PLANNING CONSULTATION RESPONSE

Application No	<u>2026/0166</u>
Proposal	Erection of 3 x retail units (Use Class E) with car parking, EV charging points and associated works following the demolition of the existing buildings/structures.
Address	Land west of Brampton Road, Wombwell, Barnsley
Date of Consultation Reply	12/05/26
Consultee	Highways Development Control

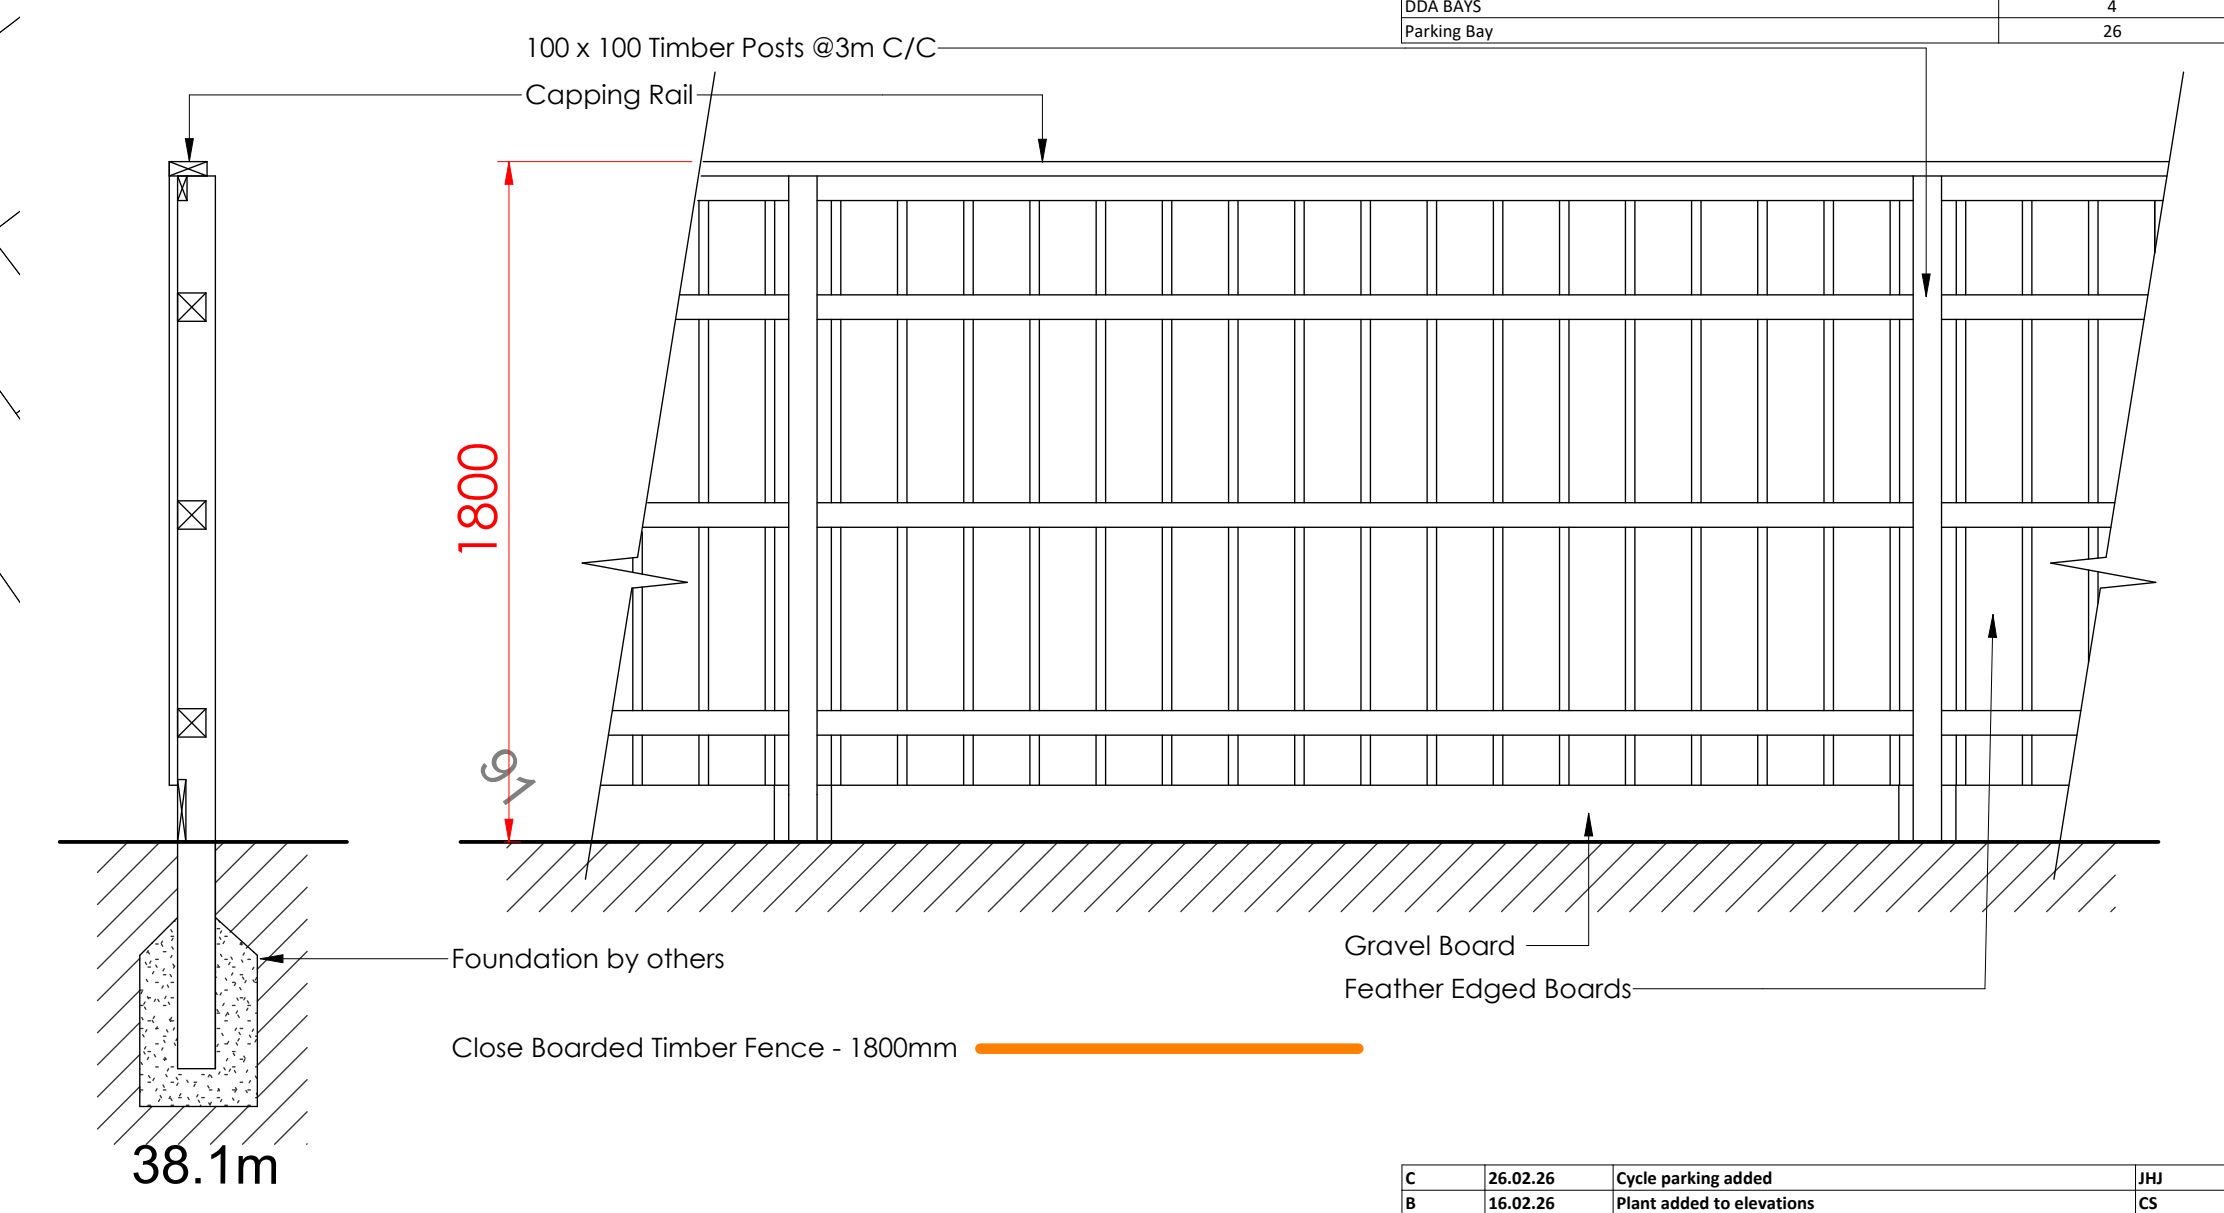
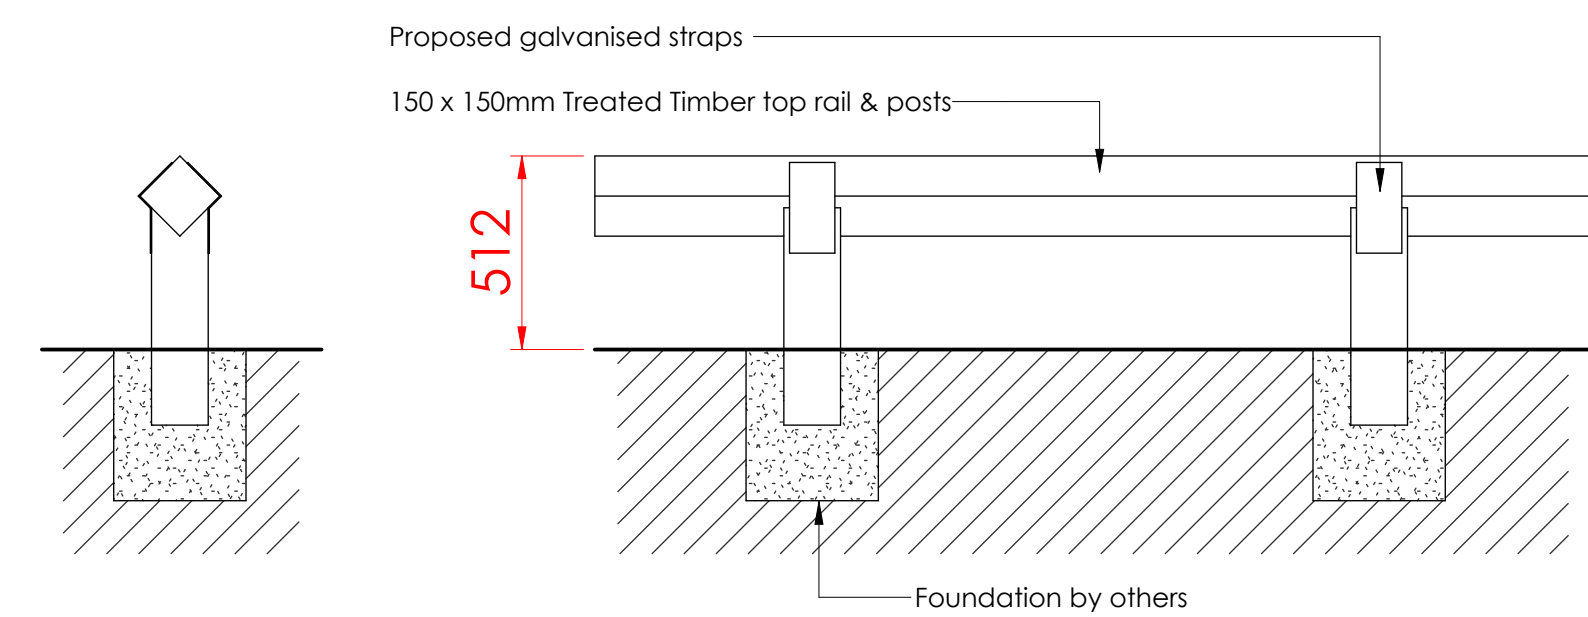
Whilst the redevelopment of the site for commercial purposes is not objected to in principle, insufficient information has currently been submitted to enable us to fully assess the impact of the development proposal on the operation and safety of the surrounding highway network.

Given the scale of the proposed development, a Transport Statement and Travel Plan will be required in support of the application. The Transport Statement should include an assessment of the anticipated trip generation associated with the proposed uses, parking demand, servicing arrangements and the impact upon the local highway network. I would also expect to see swept path analysis for the internal arrangement to ensure delivery vehicles are able enter and manoeuvre within the site.
